Application for a Non-Material Amendment Following a Grant of Planning Permission

Two storey side extension, loft conversion and internal alterations

2023/1637/HSE

Omission of the use of Natural Stone from the principle elevation, and its substitution with an alternate material as specified on the latest revision of the planning drawings.

Draw No H6759 / 100B

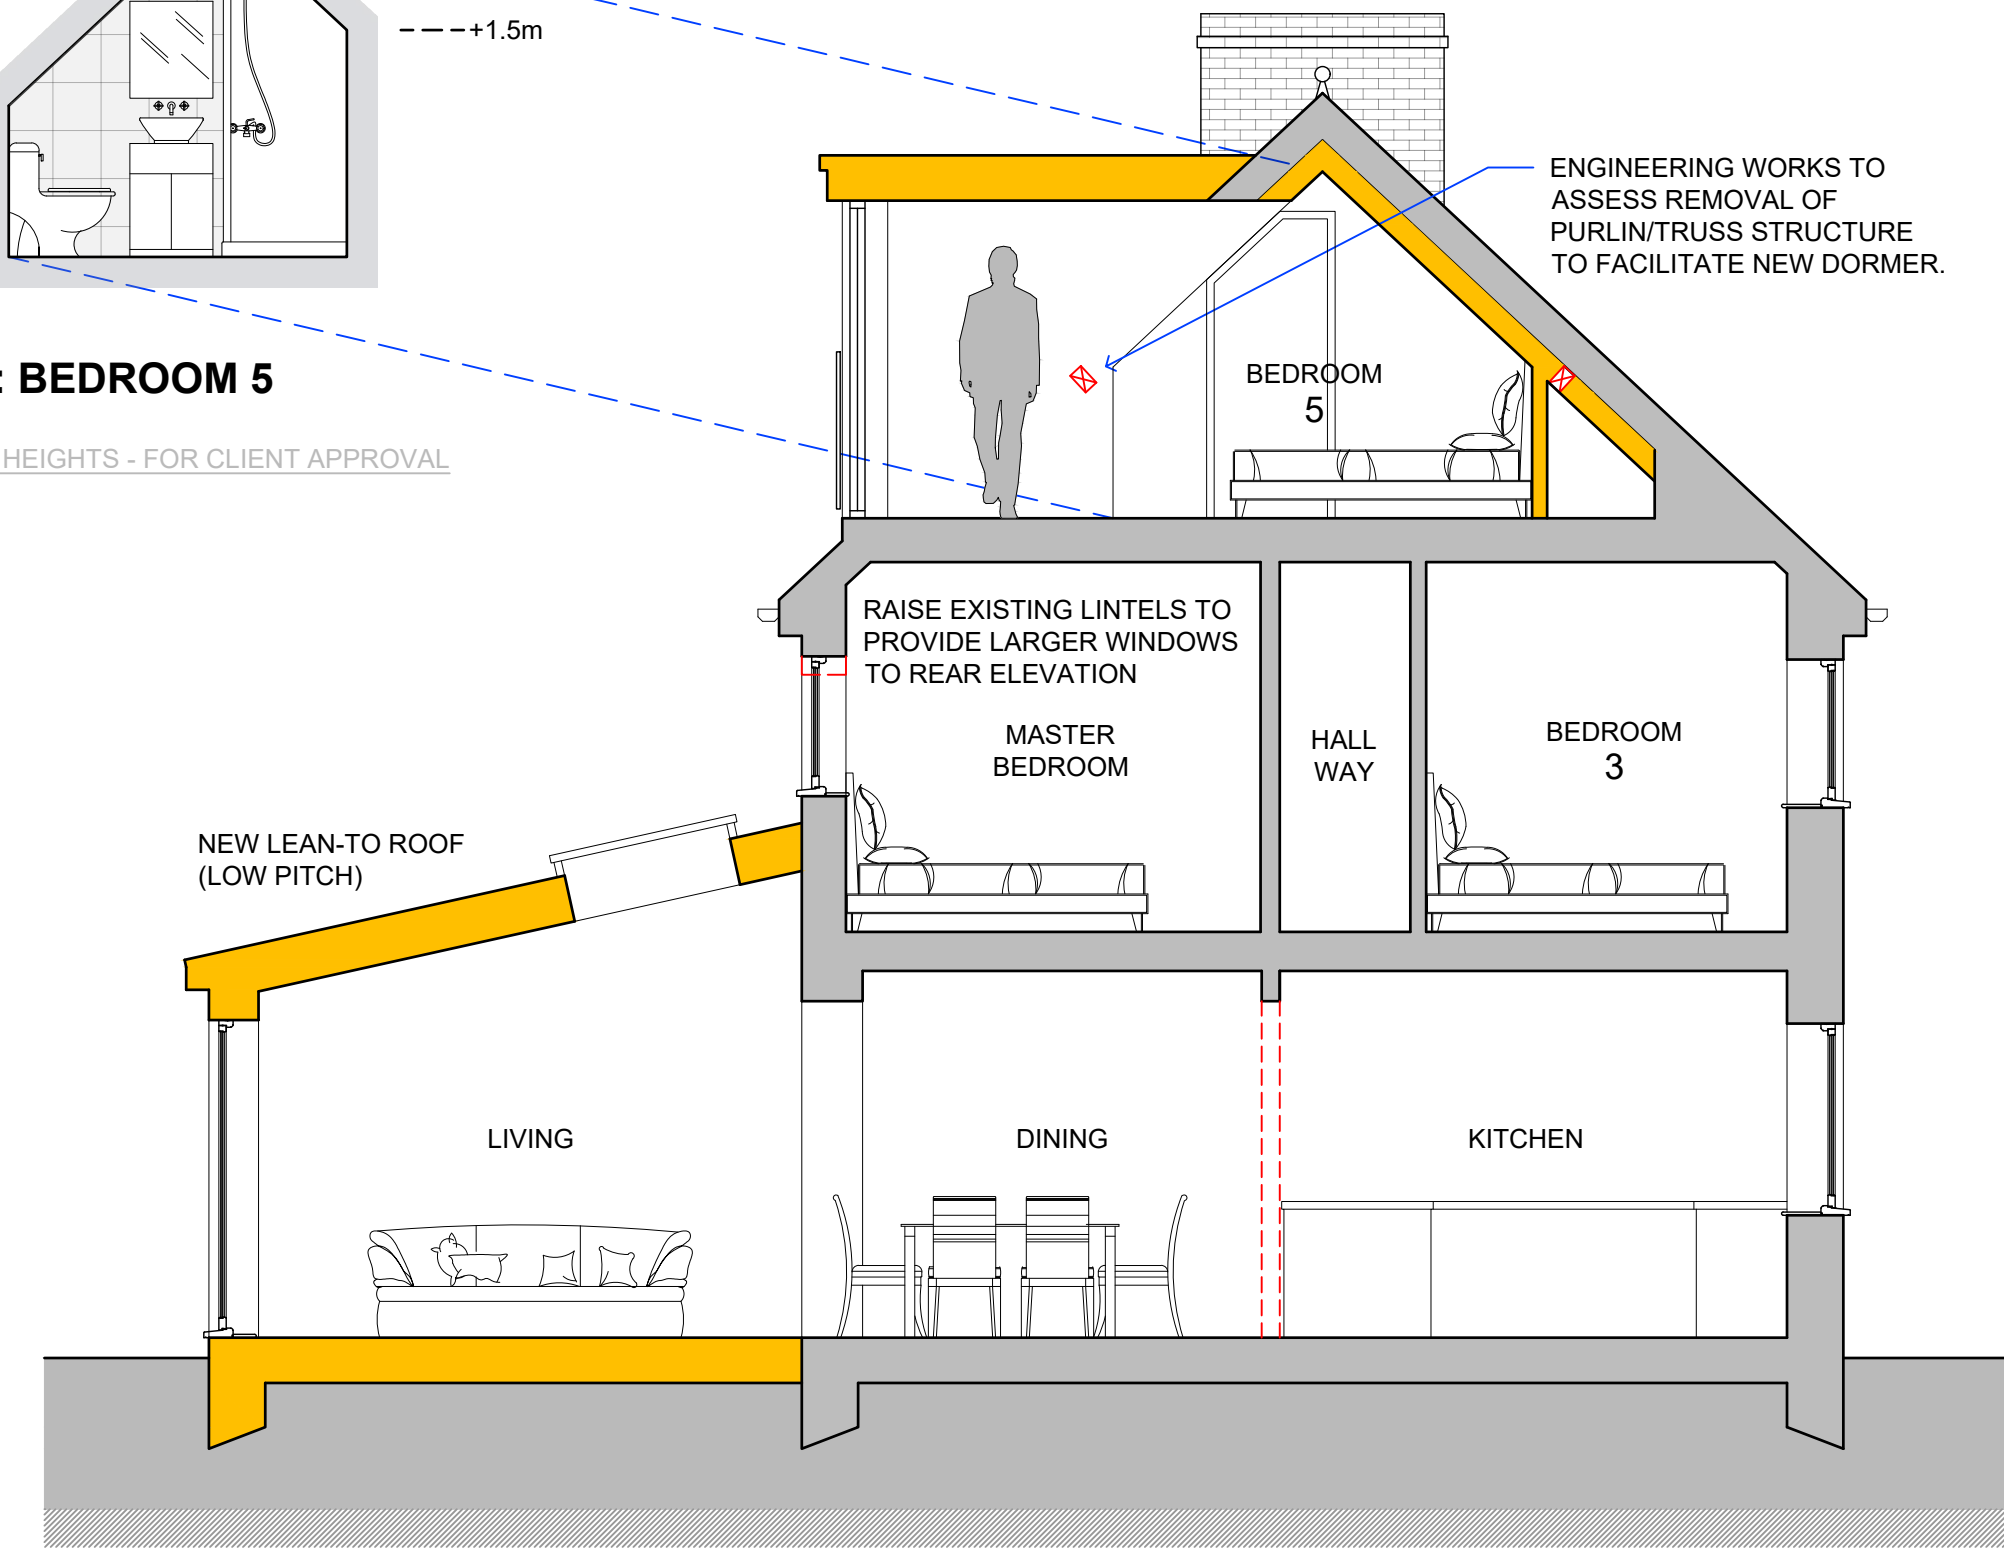
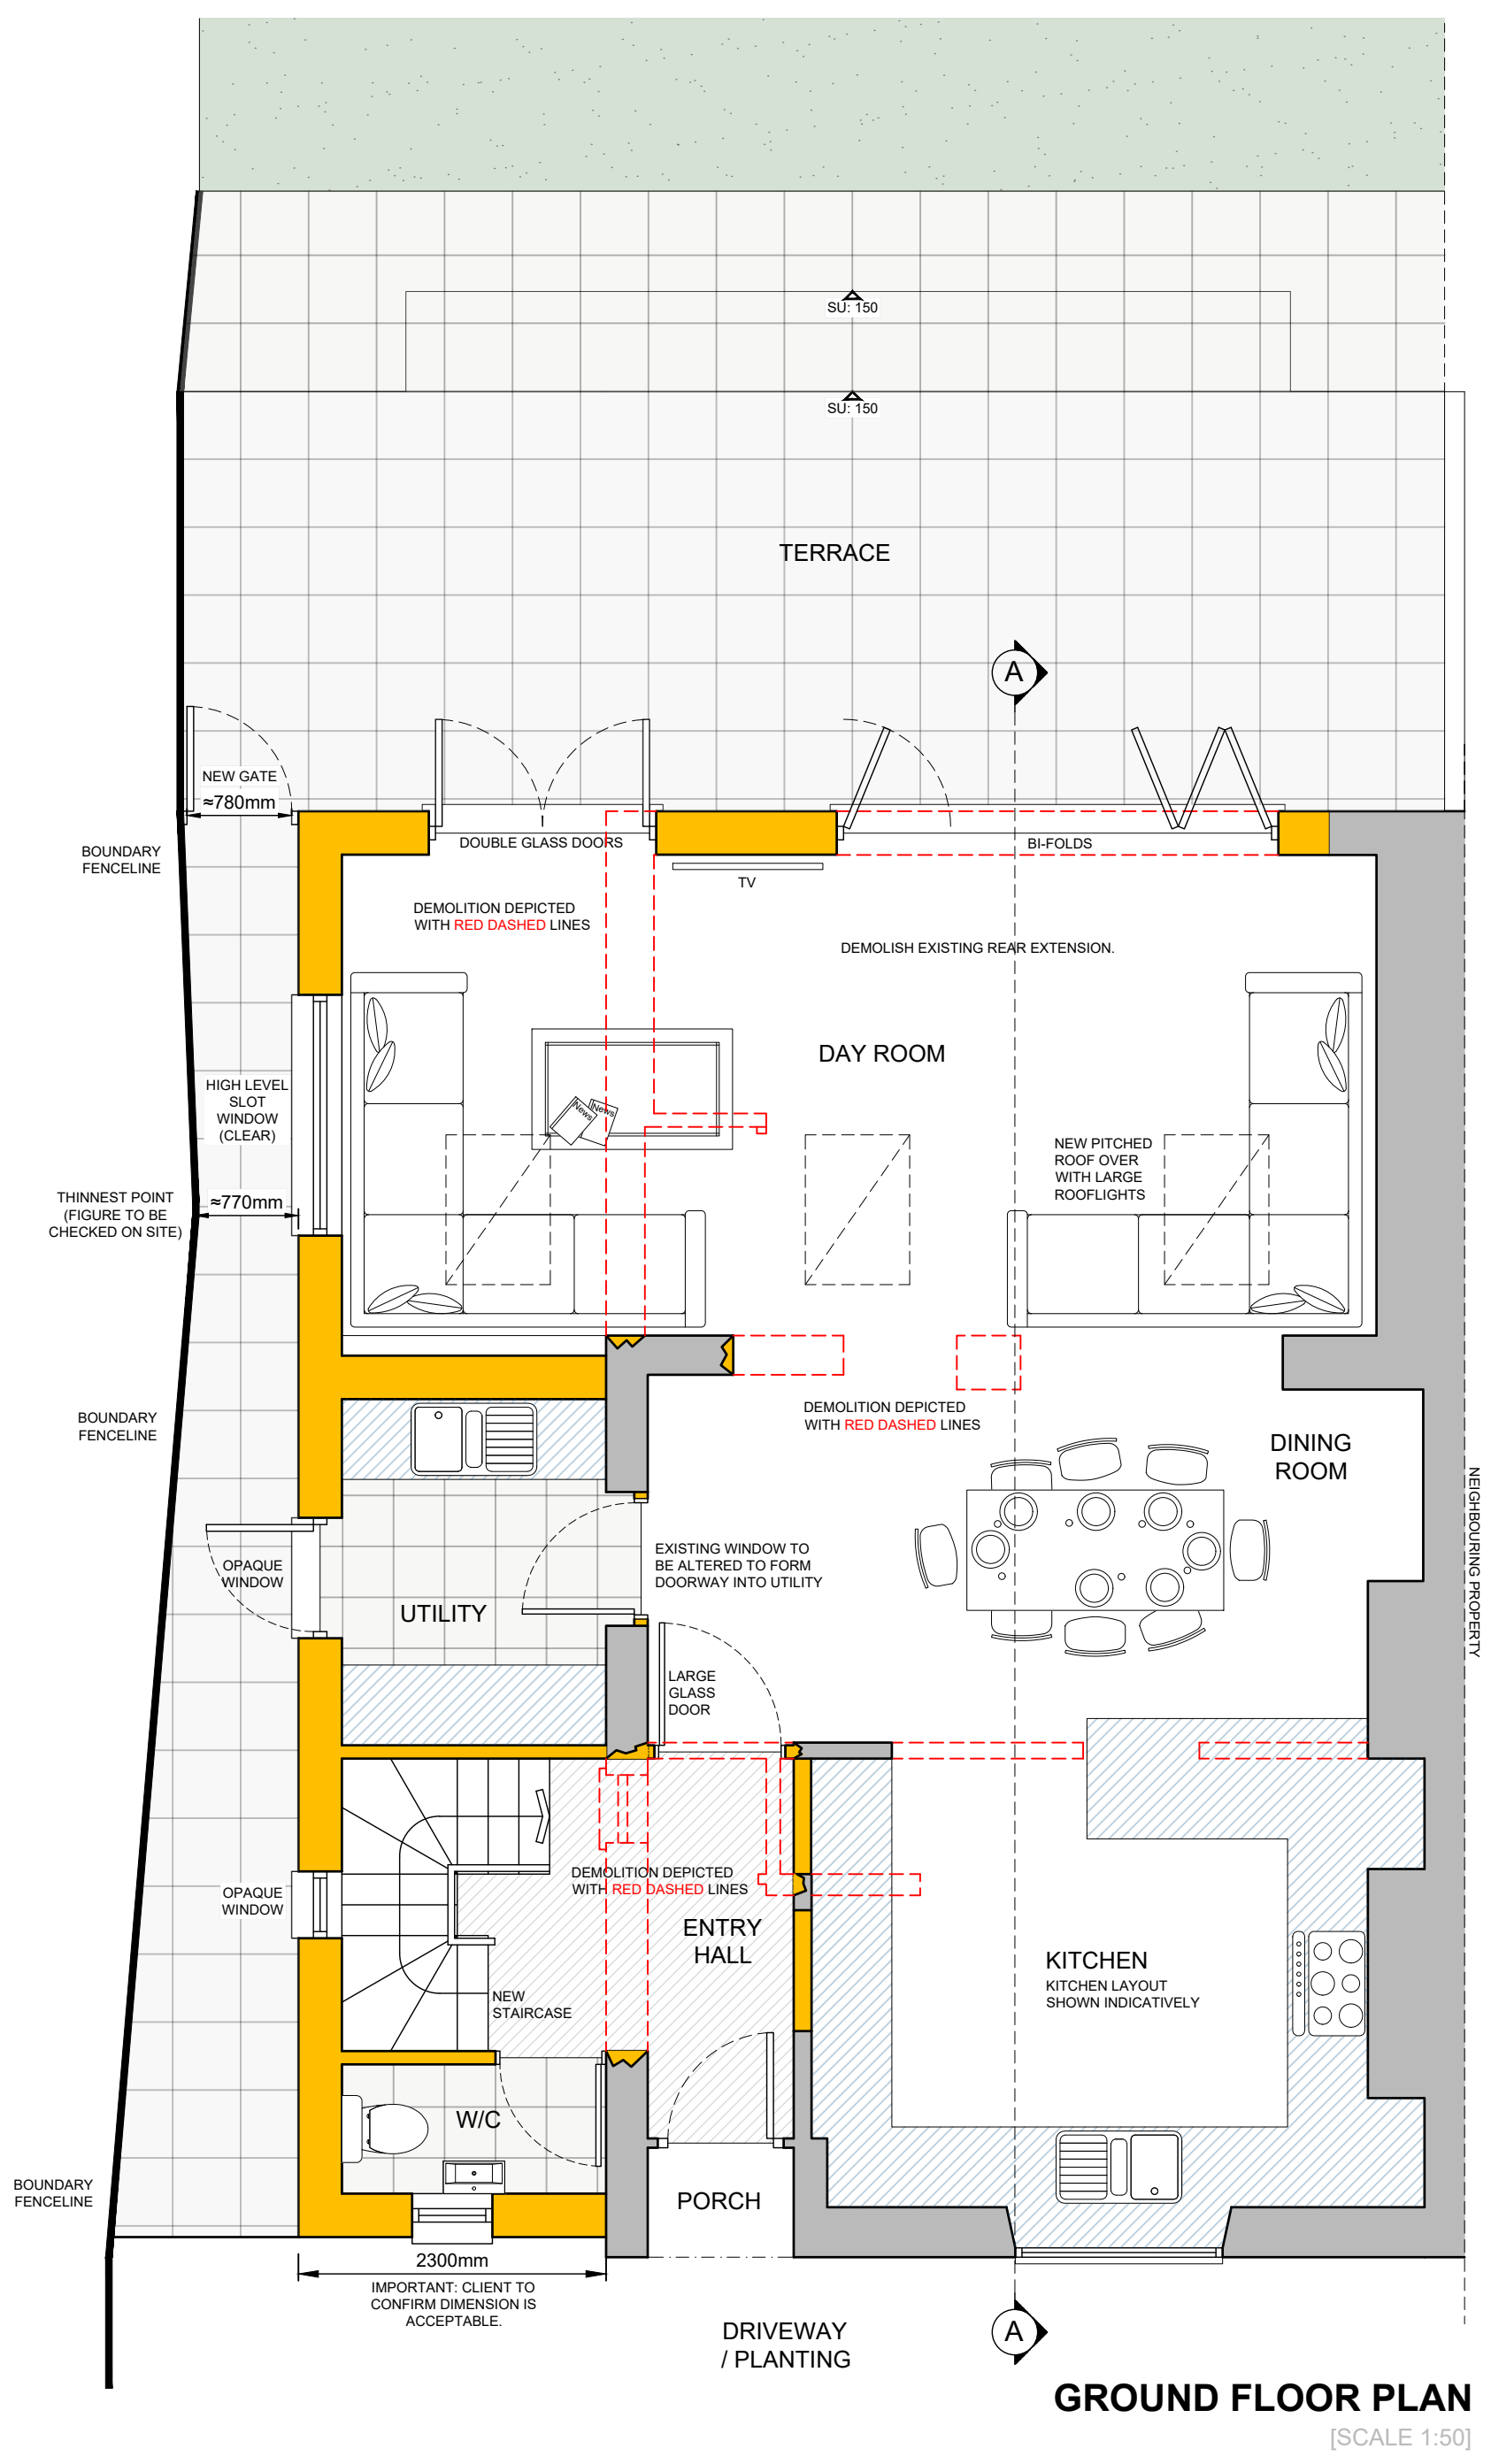
Due to difficulties with sourcing matching, now unavailable historically sourced stone, and due to mitigate overall build cost to excessively high costs to undertake the works with natural stone.
